Please ask for: Nicola Moore
Email: nicola.moore@arun.gov.uk
Telephone: Ext 37944
Our Ref: FP/114/21/HH
Your Ref:
Date: 18th May 2021

Application for Planning Permission for Works or Extension to a Dwelling

Development: Removal of existing structure & erection of single storey front extension.
Location: 14 Sutton Close Felpham PO218EY

sheet 2 of 2

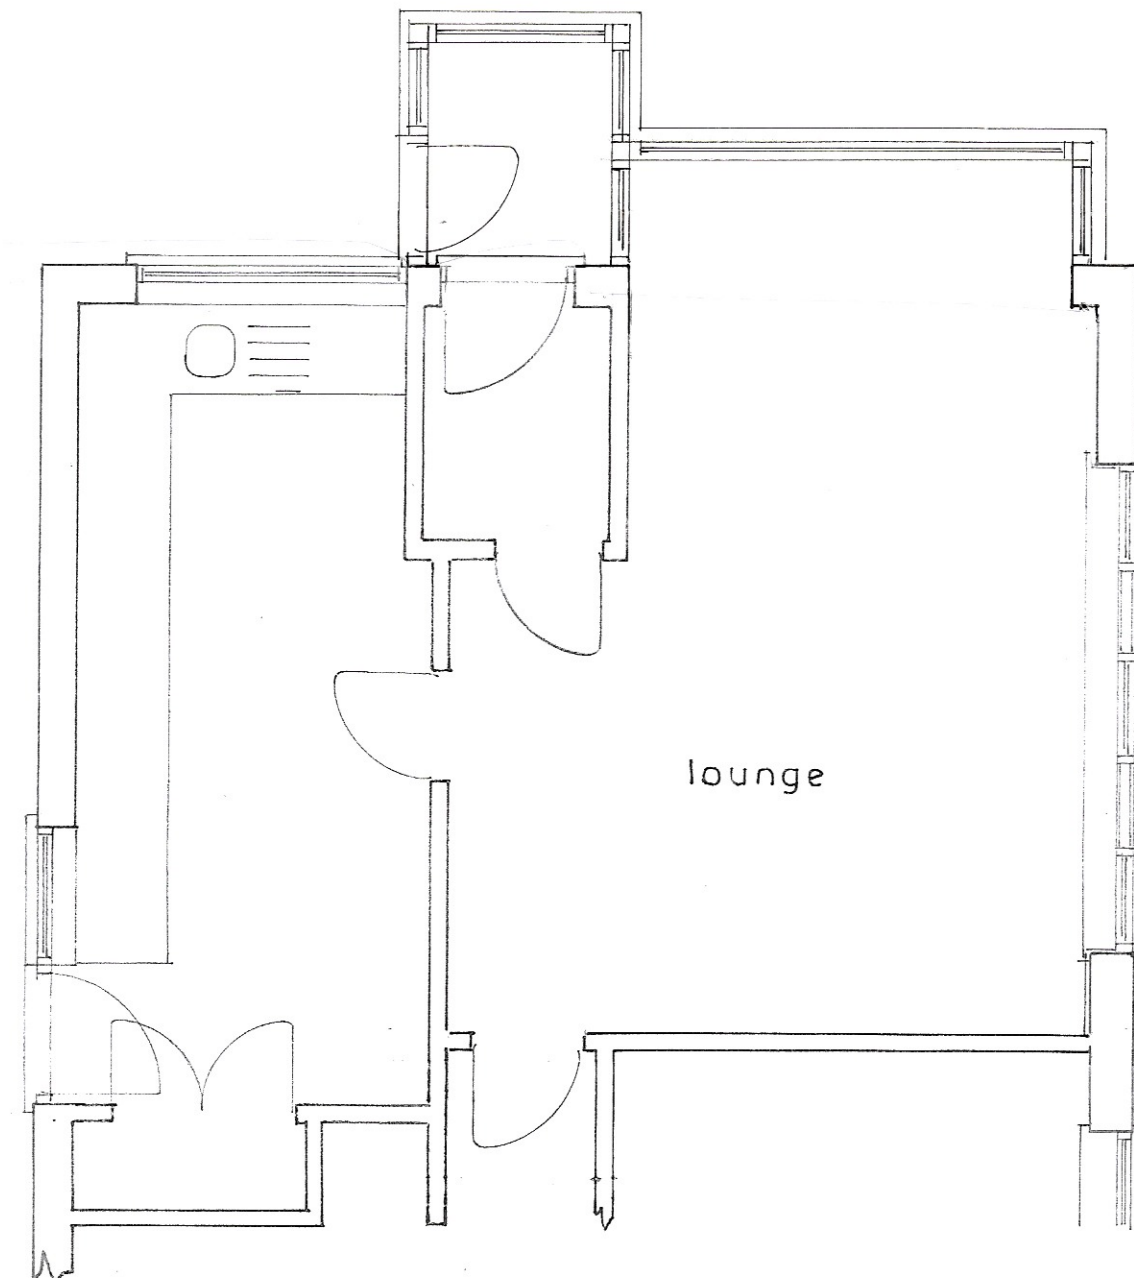
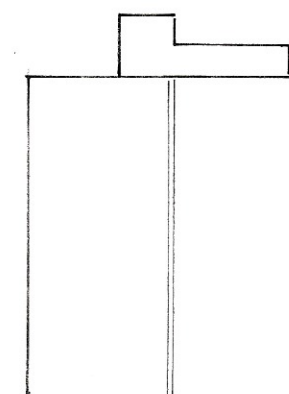
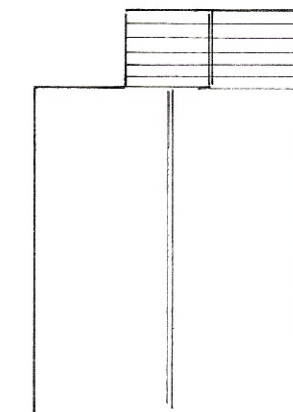
Please check the North point on the Location Plan and that the elevations are labelled correctly as on checking our map they do not appear to be correct. Please amend accordingly and re submit or confirm if correct.
